CITY OF PORTLAND, MAINE

February 23, 2018

Project Name: Canal Landing Phase III
Address: 400 West Commercial Street
Applicant: Canal Landing, LLC
Planner: Matthew Grooms

Project ID: 2017-293
CBL: 059-A-003

2 | EAST ELEVATION
SCALE: 1/8"=1'-0"

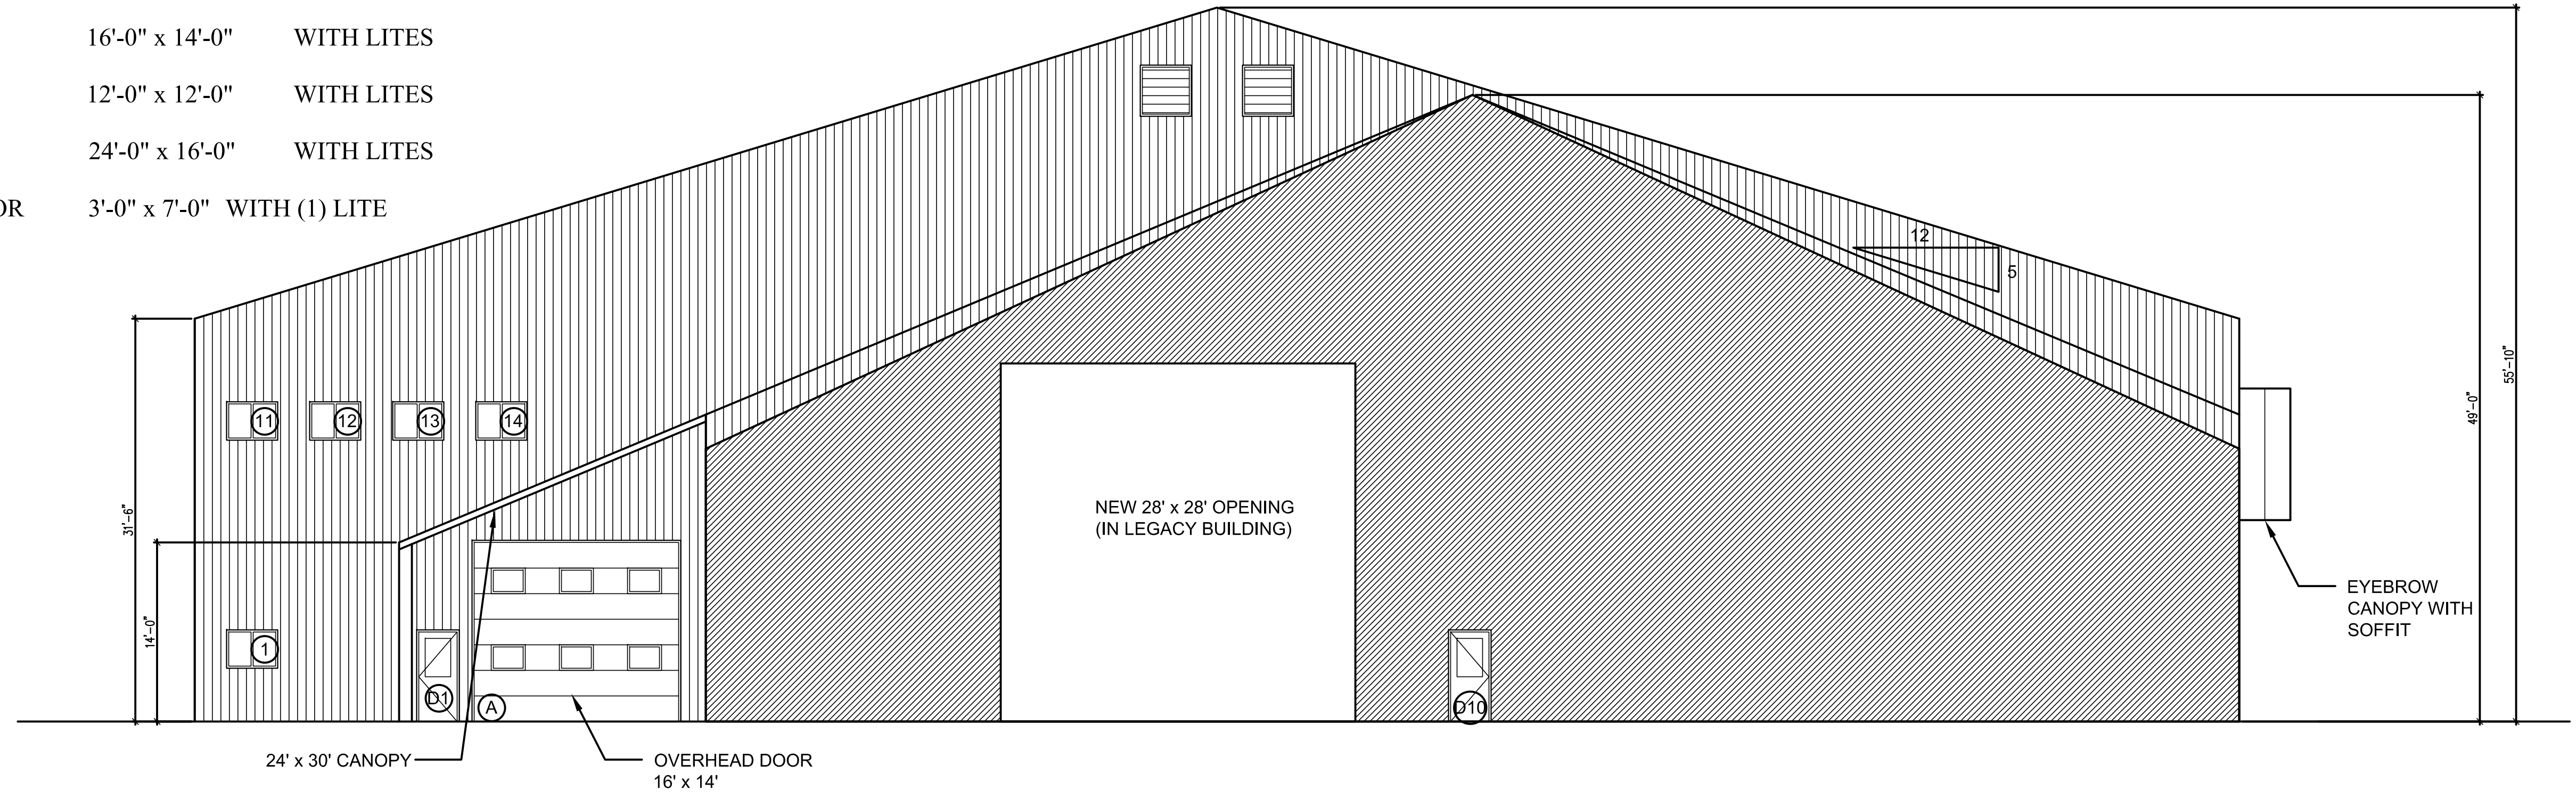
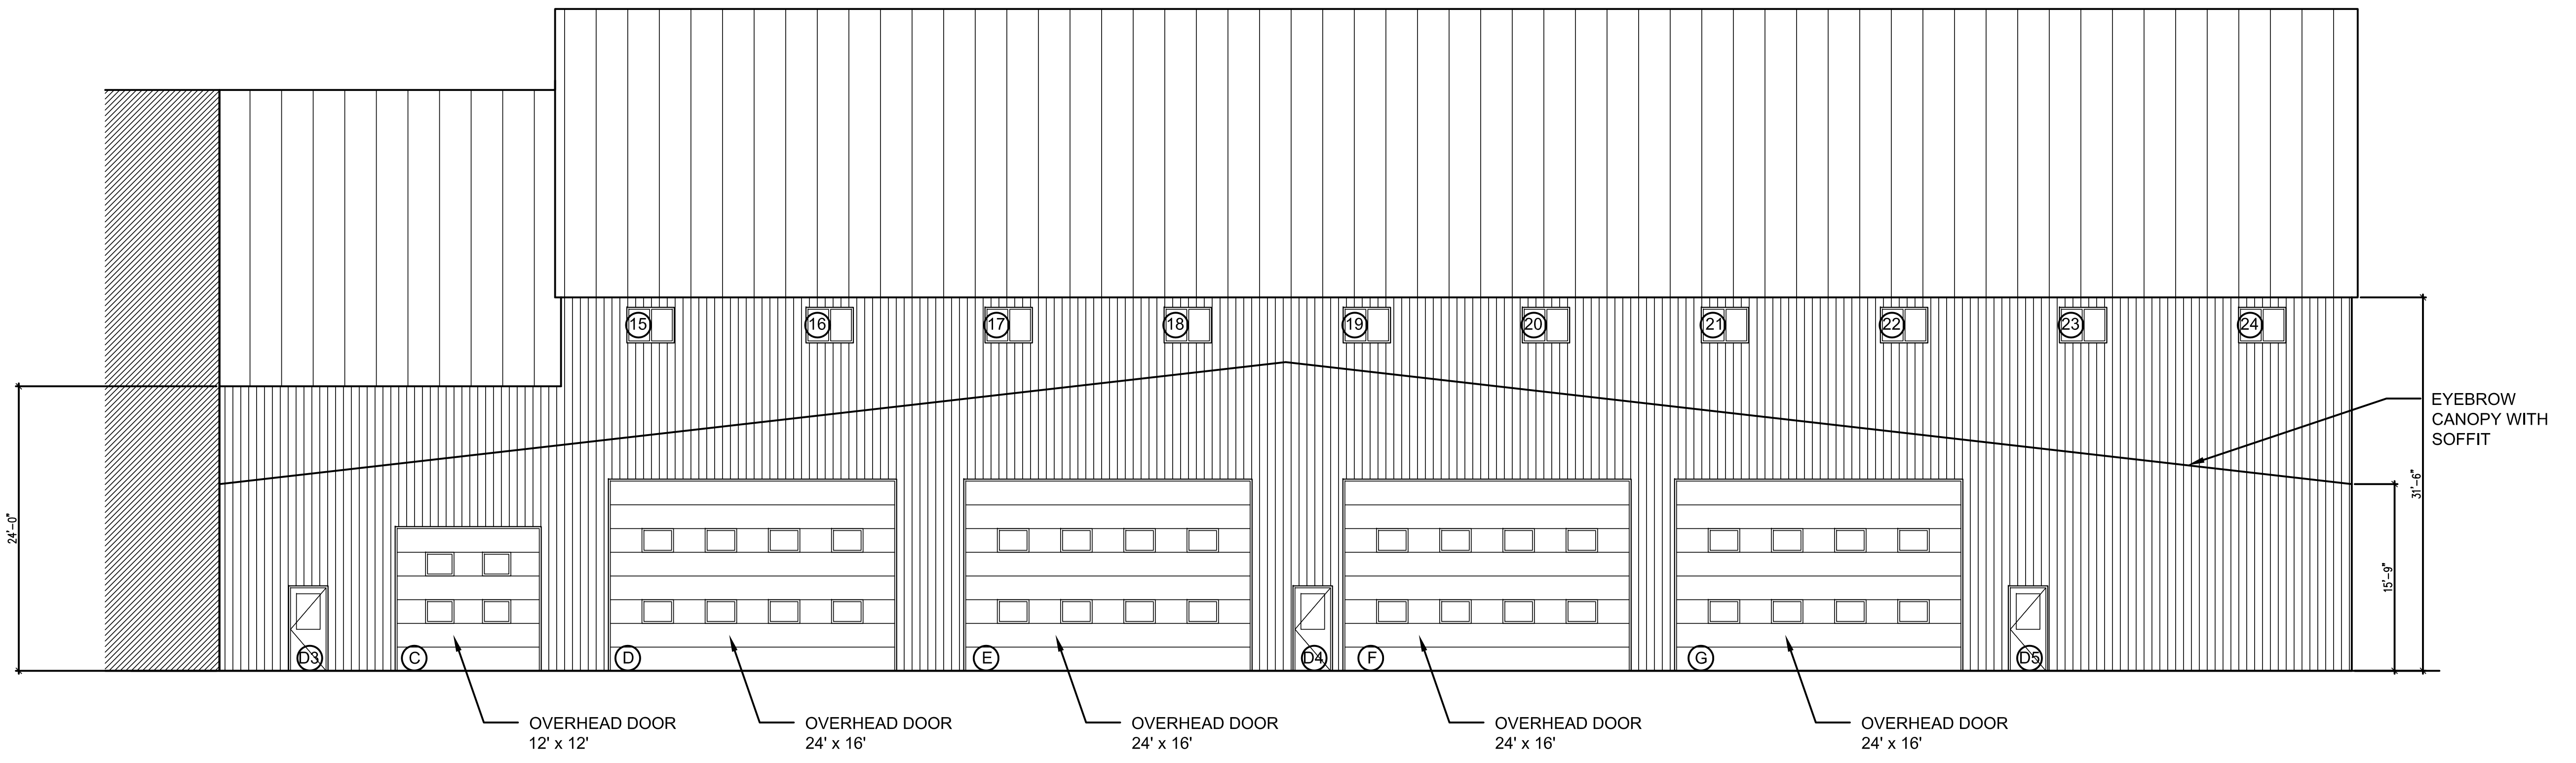
4. Rooftop mechanical equipment shall be screened from public view and long views of the building shall be considered. Building articulation shall be reviewed on the western edge of the Commercial Street building. The applicant shall provide revised elevations and roof plans for review and approval by Planning Staff
